AQUIND INTERCONNECTOR

Consultation Report – Appendix 1.7D Marine
Specific – Briefing Note of Meeting with MMO
18 July 2019

DATE: 14 NOVEMBER 2019

Briefing Note for Ongoing Consultation: Responses to Marine Management Organisation PEIR feedback

File name \\UK.WSPGROUP.COM\CENTRAL DATA\PROJECTS\62100XXX\62100616 - AQUIND VO NO.3\IE MODELS AND DRAWINGS\300 - SITE\340 - TASK 9 MARINE ROUTE\CURRENT\ENVIRONMENTAL STATEMENT\UK\REV 1\FIGURE 3.5 UK INDICATIVE SEABED PREP AREA REV1.DWG

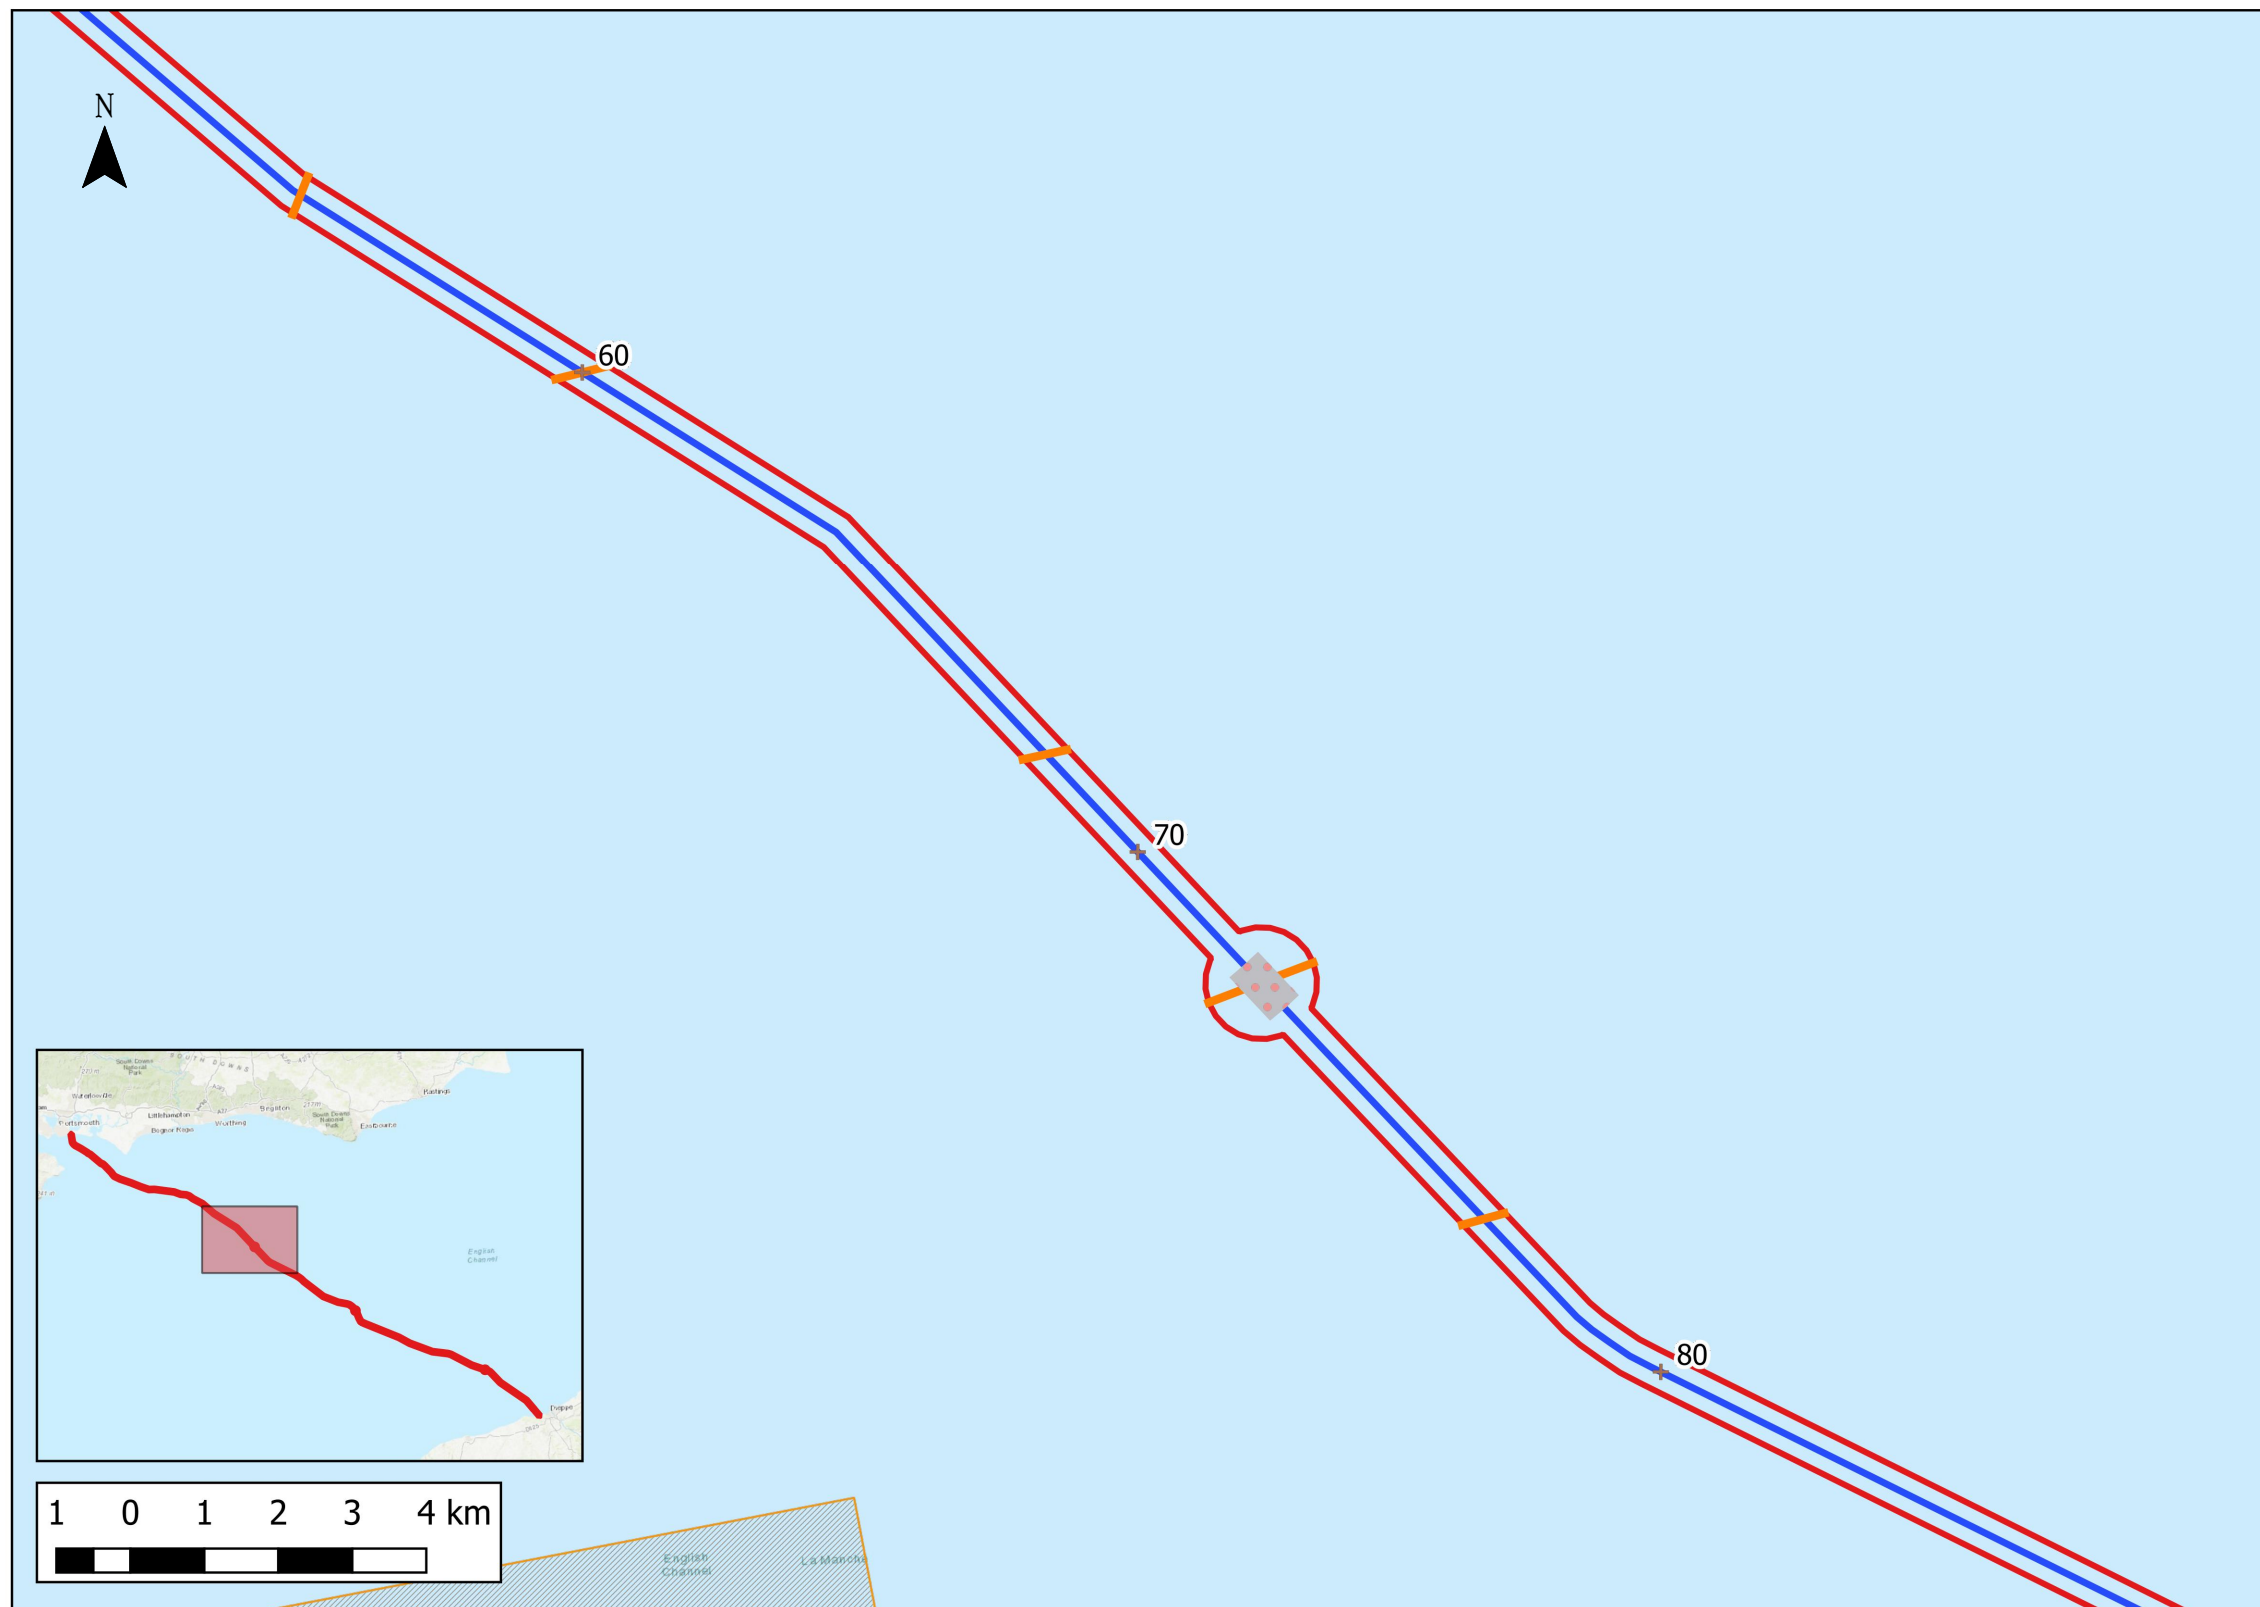
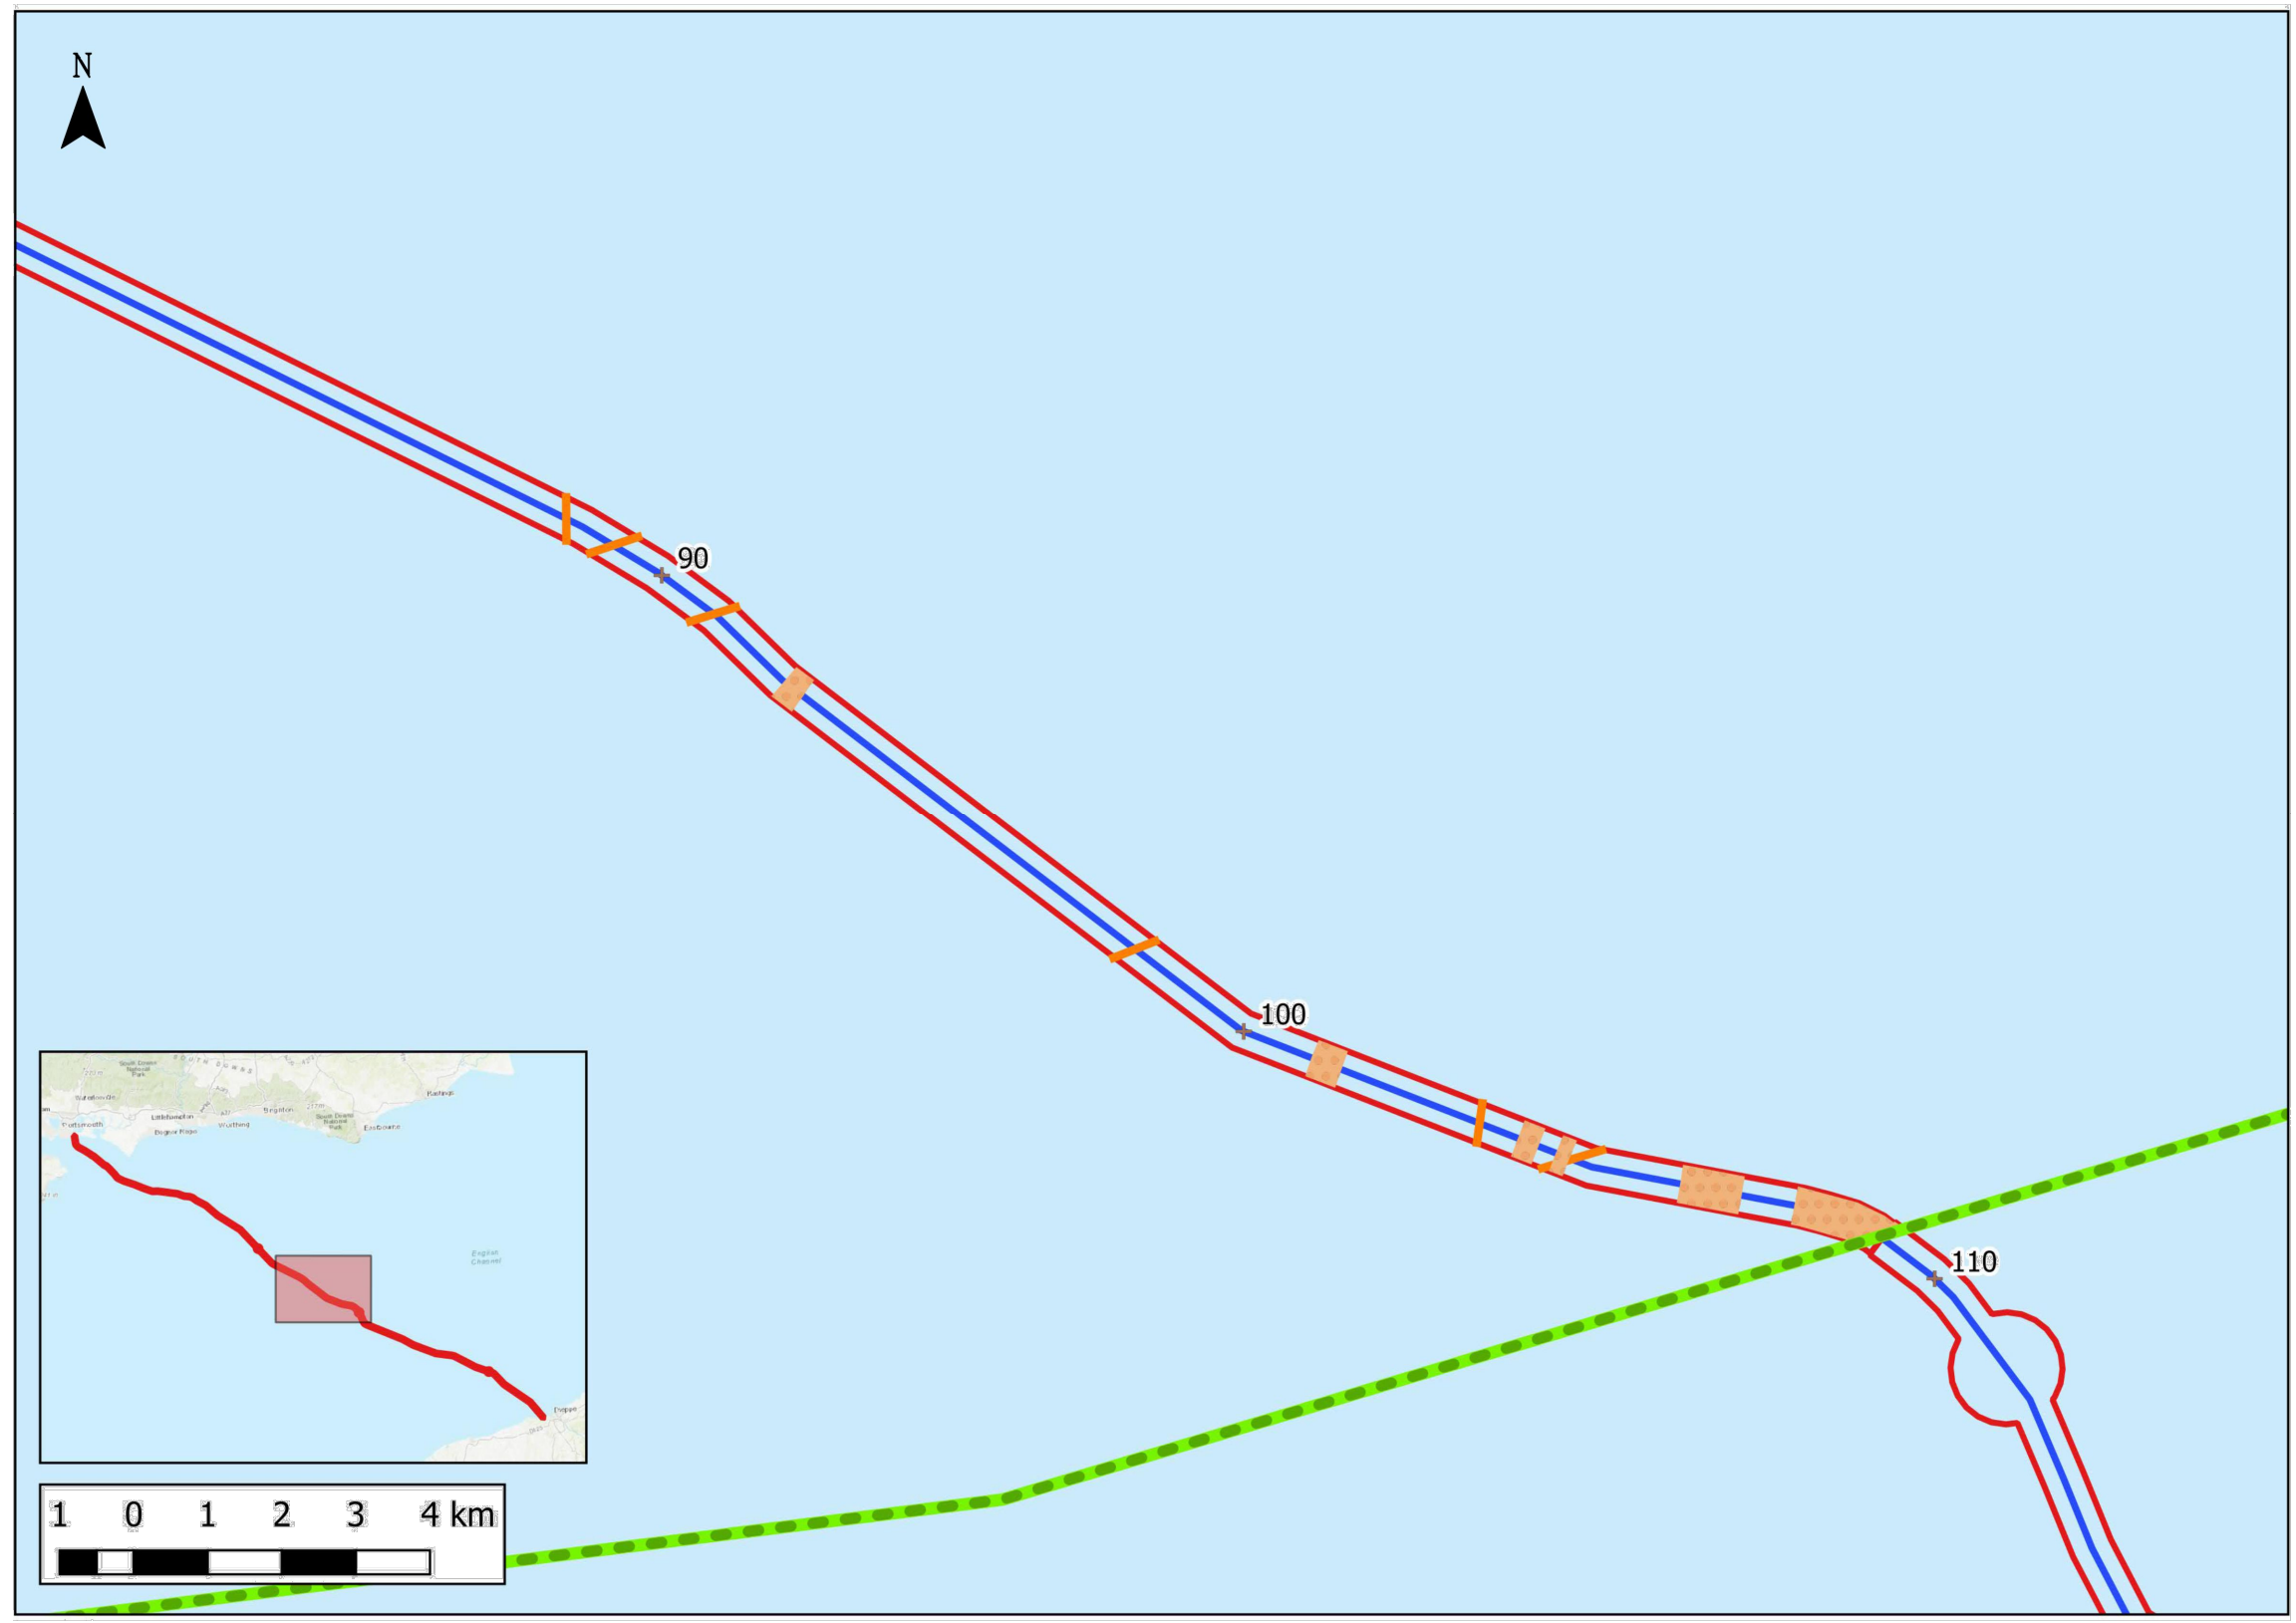
| Item | Topic | Comment | Applicant's Response | Teleconference Outcomes |
|------|--------------------|---|---|---|
| 5 | Physical Processes | Table 6.1 in the PEIR provides an overview of each comment from the scoping opinion, summarising how it has been addressed and clearly identifying the relevant section of the PEIR where this is done. Key comments in the scoping included: · A request to include tidal data for model validation, which has been undertaken (described in section 6.5). · A request to consider seabed features as receptors, which has been acknowledged in the PEIR and the applicant states that this will be accounted for in the ES. · A request for further detail on specific EIA approach and cross-referencing to other ES chapters to identify indirect linkages to other chapters has been (section 6.4 and chapter 4) · Details of embedded mitigation measures which were incorporated into project design have been described in section 6.7 and table 6.20. · More detail of non-burial cable protection was requested and further detail has been provided in chapter 3 and figure 3.5 | Acknowledged. | Cefas and the MMO have no further response. |
